**From:** Hill, Grace <Grace.Hill@e-lindsey.gov.uk>  
**Sent:** 29 January 2026 09:53  
**To:** Hill, Jess  
**Cc:** \_planningadvice  
**Subject:** H14-1288-25 ecology comments

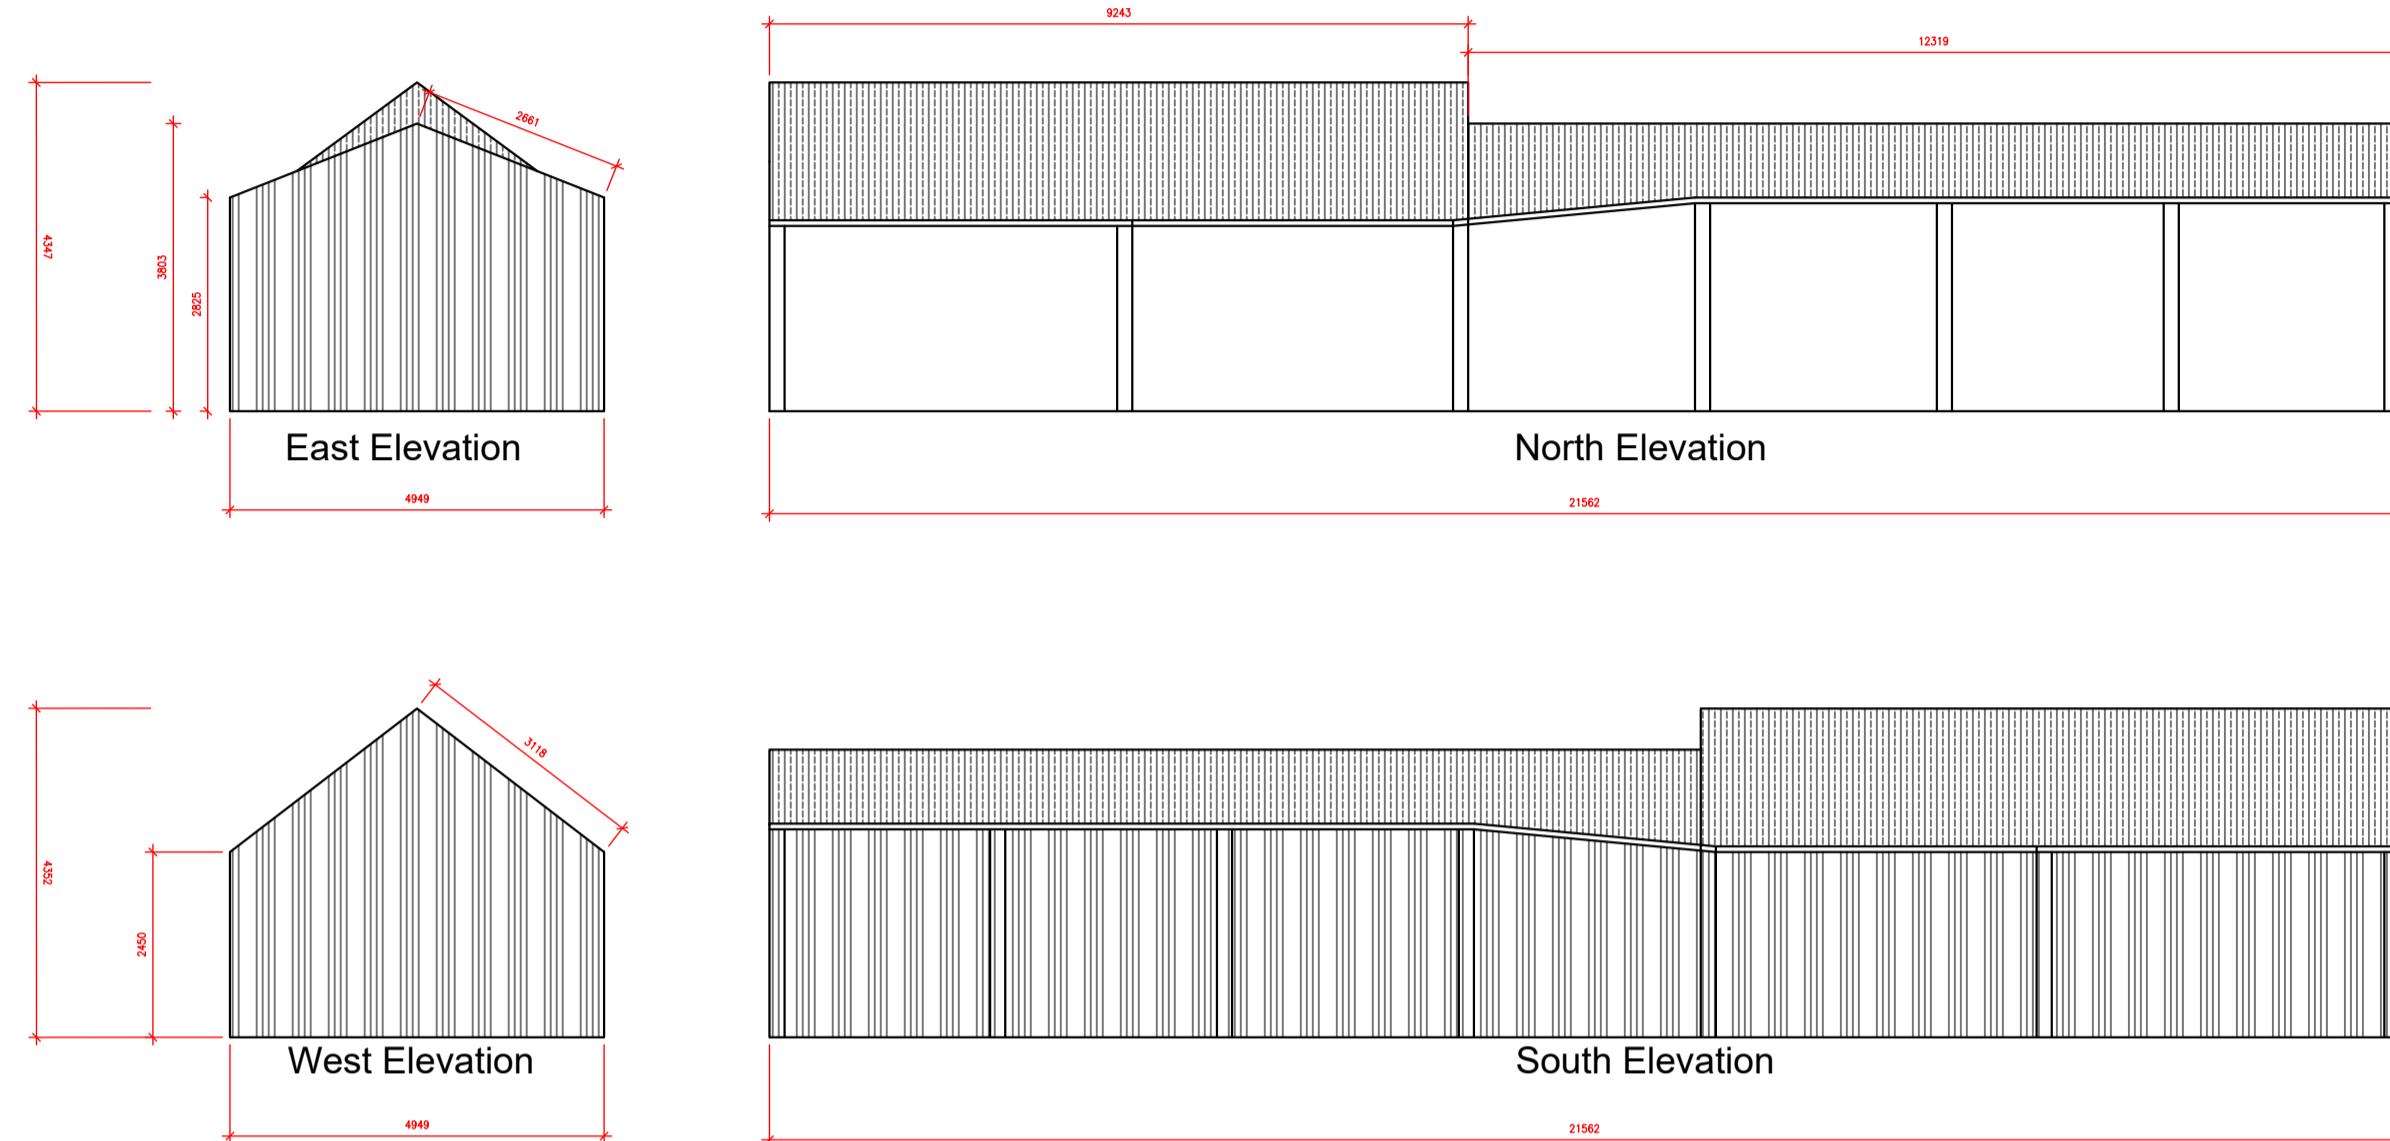
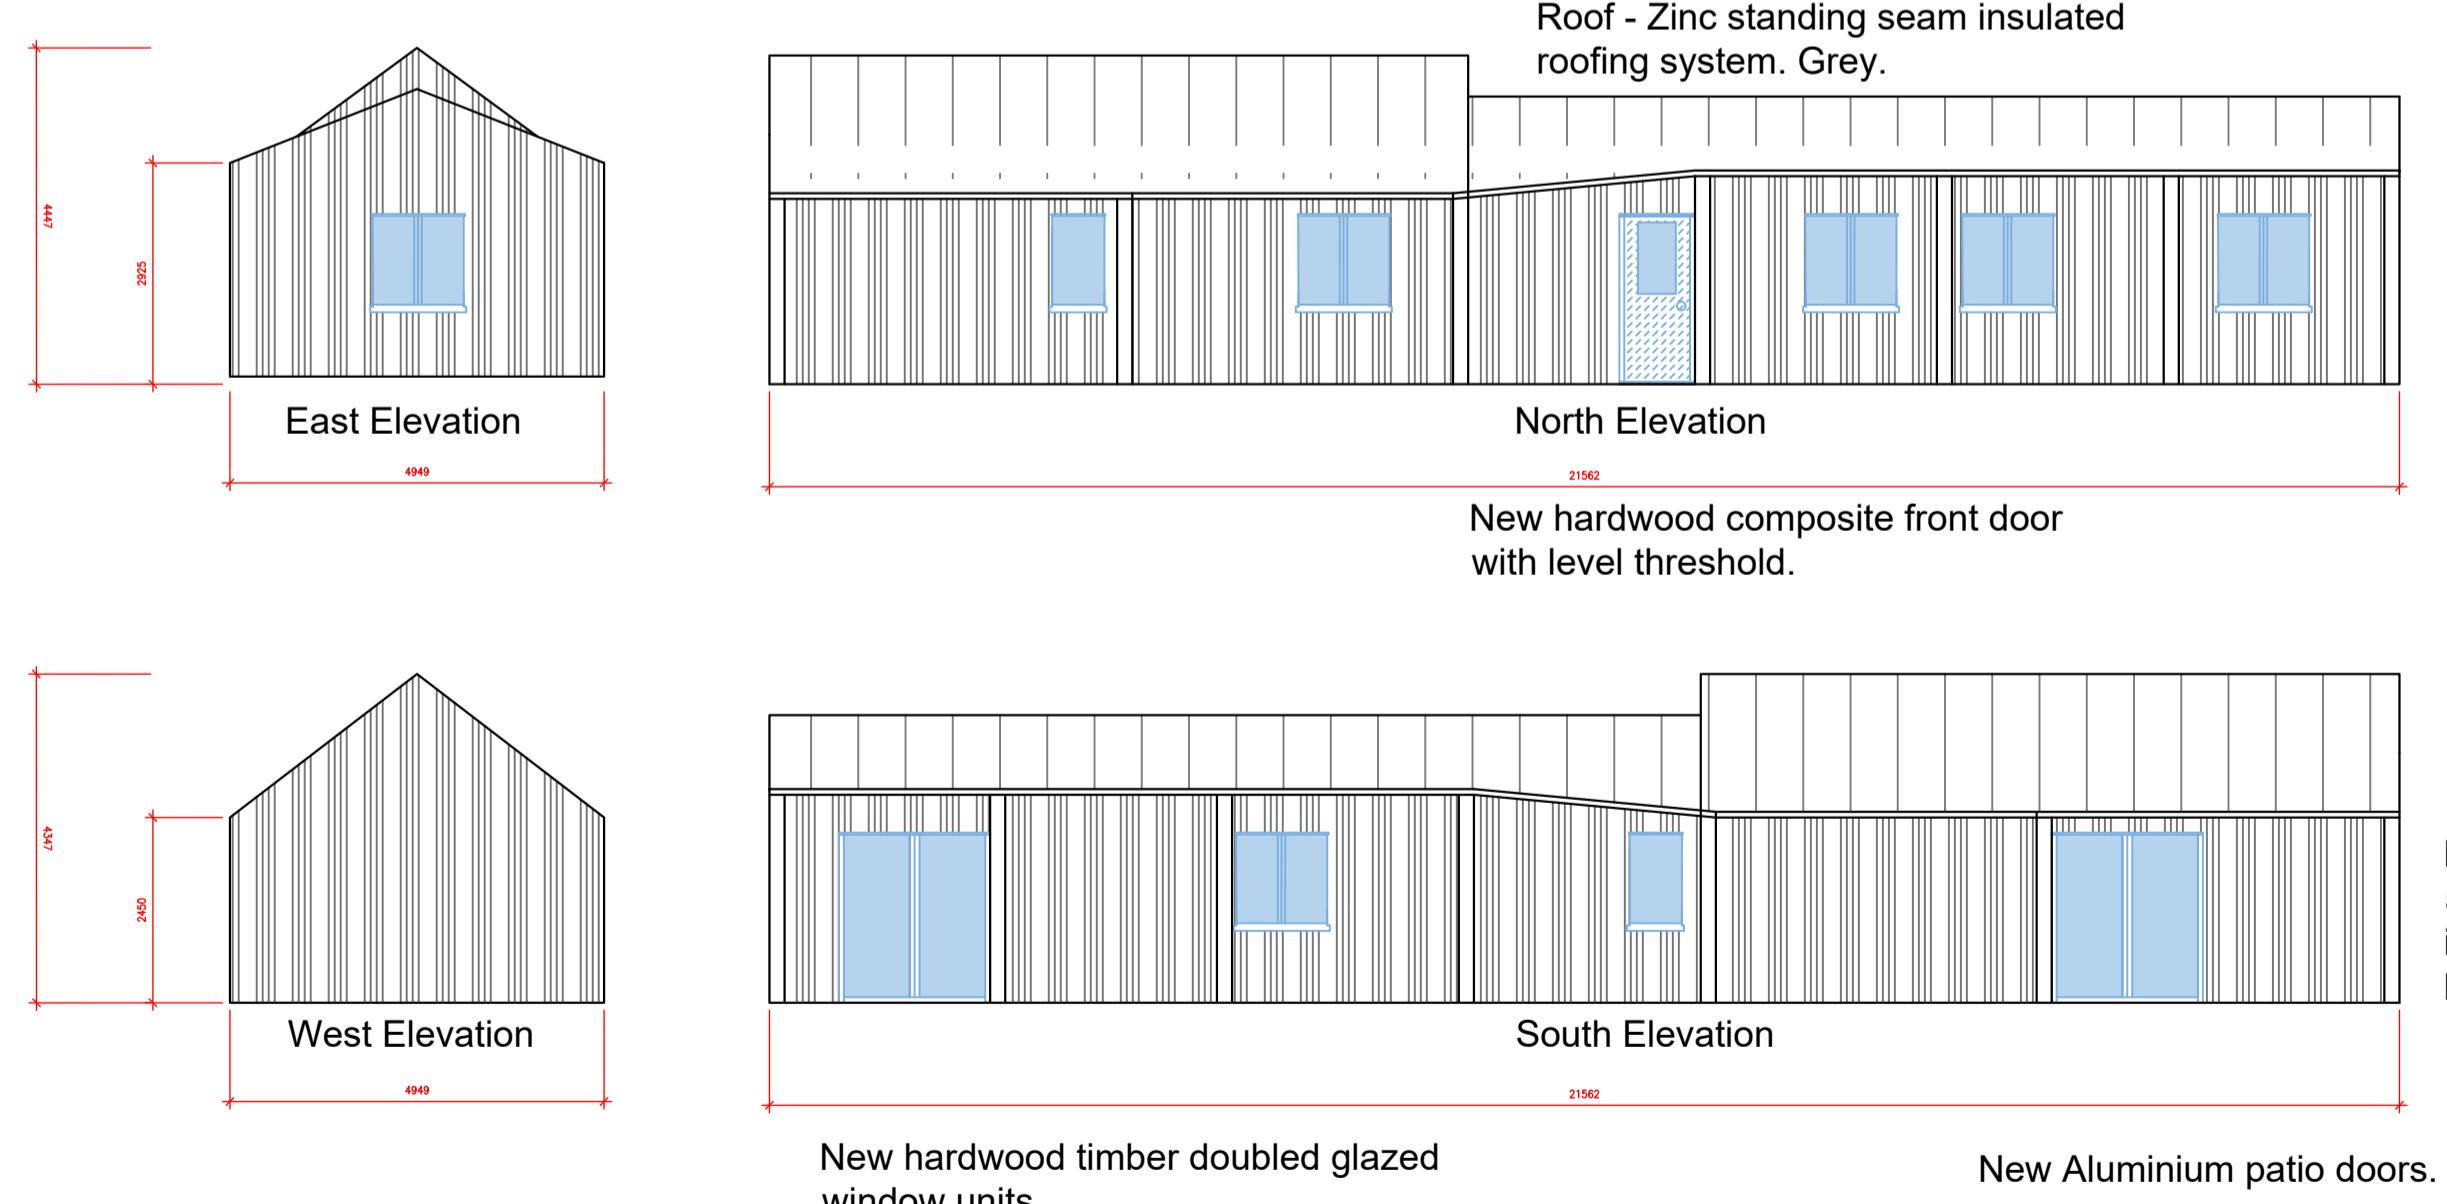
We request that at least 1 integrated bird box and 1 integrated bat box are added to the external fabric of the dwelling. The bricks must be installed during the construction phase and retained thereafter for the lifetime of the development. These are required to enhance biodiversity and to be in line with Local Plan Policy 7.2.14.
